CITY OF PORTLAND BUILDING PERMIT

297 BRACKETT ST

PERMIT ID: 2013-00902

has permission to **Interior renovations to 2nd floor and change a few windows.**

297 BRACKETT - PROPOSED
WINDOW SCHEDULES

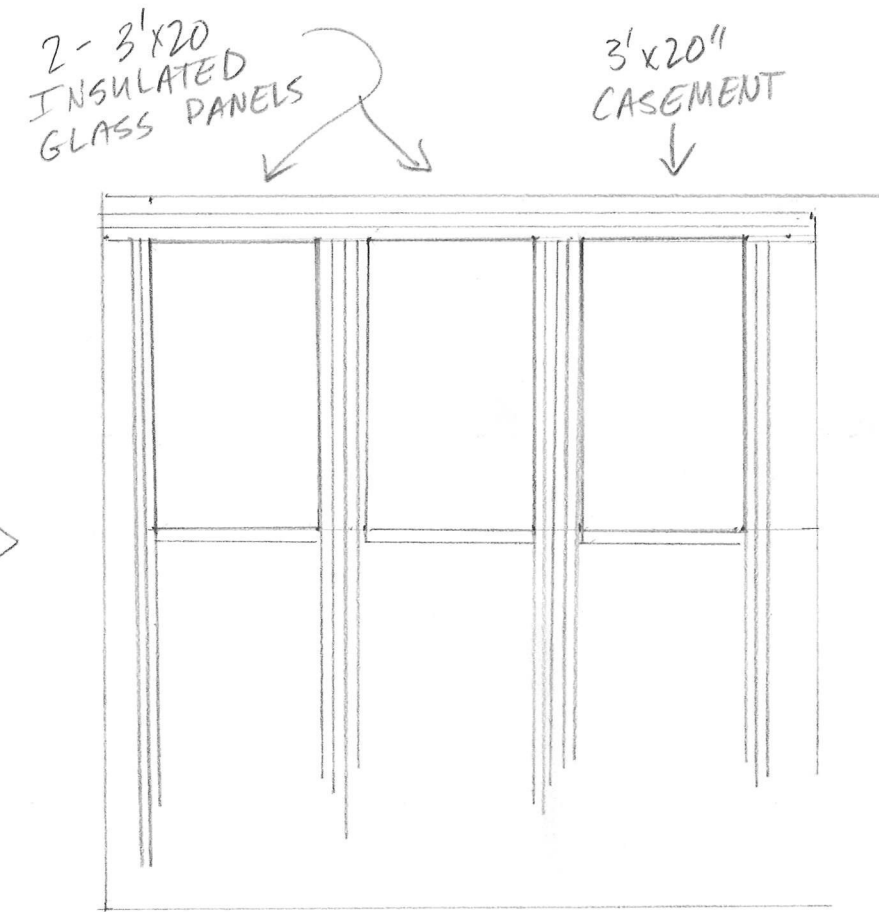
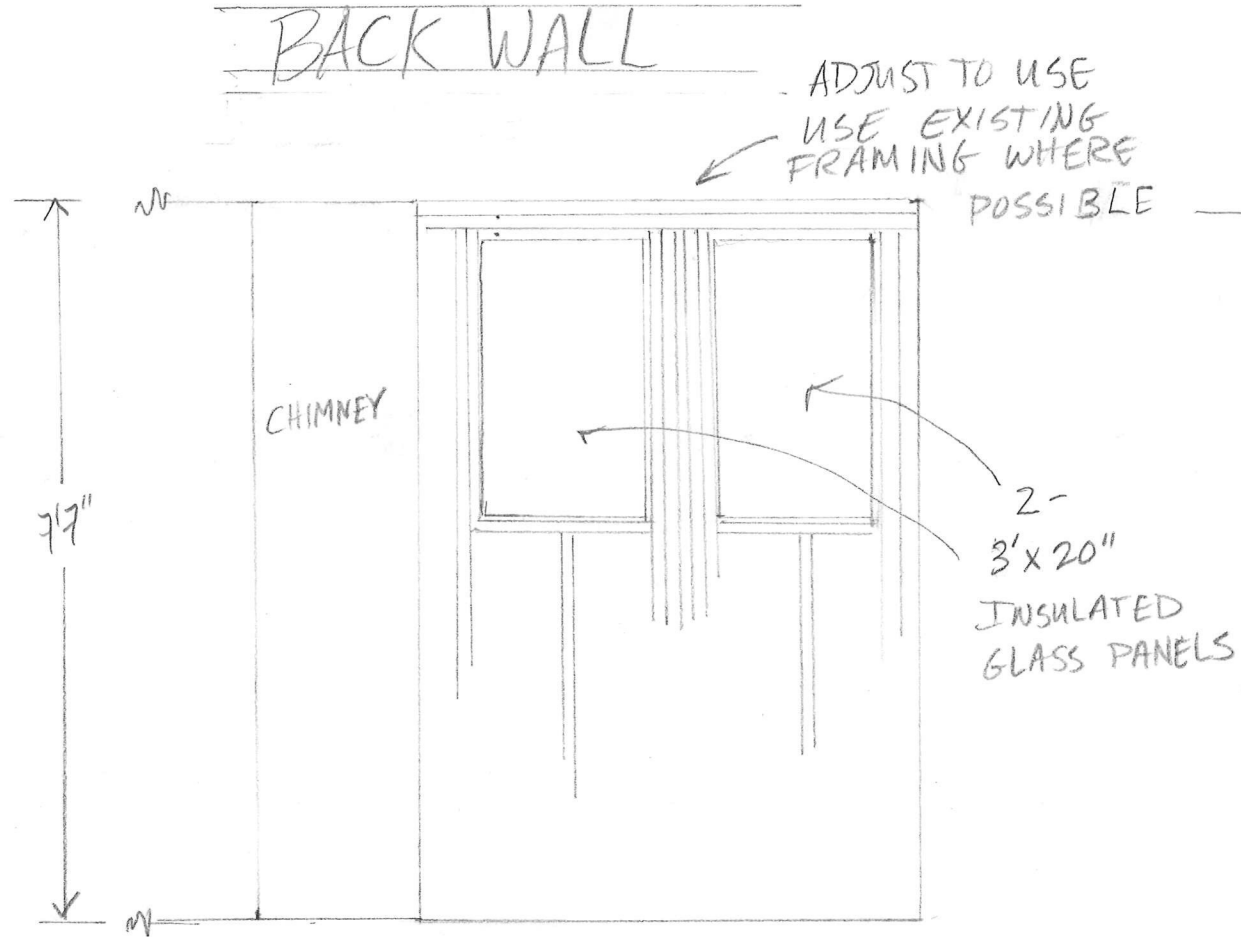
5) A code compliant emergency escape shall be provided in any newly created bedroom. Window sills in locations more than 72 inches from finished grade shall be a minimum of 24 inches (no higher than 44 inches) above the finished floor of the room, or in compliance with Section R612.4.2

R612.2 Window sills. In dwelling units, where the opening of an operable window is located more than 72 inches above the finished grade or surface below, the lowest part of the clear opening of the window shall be a minimum of 24 inches above the finished floor of the room in which the window is located. Operable sections of windows shall not permit openings that allow passage of a 4 inch diameter sphere where such openings are located within 24 inches of the finished floor.
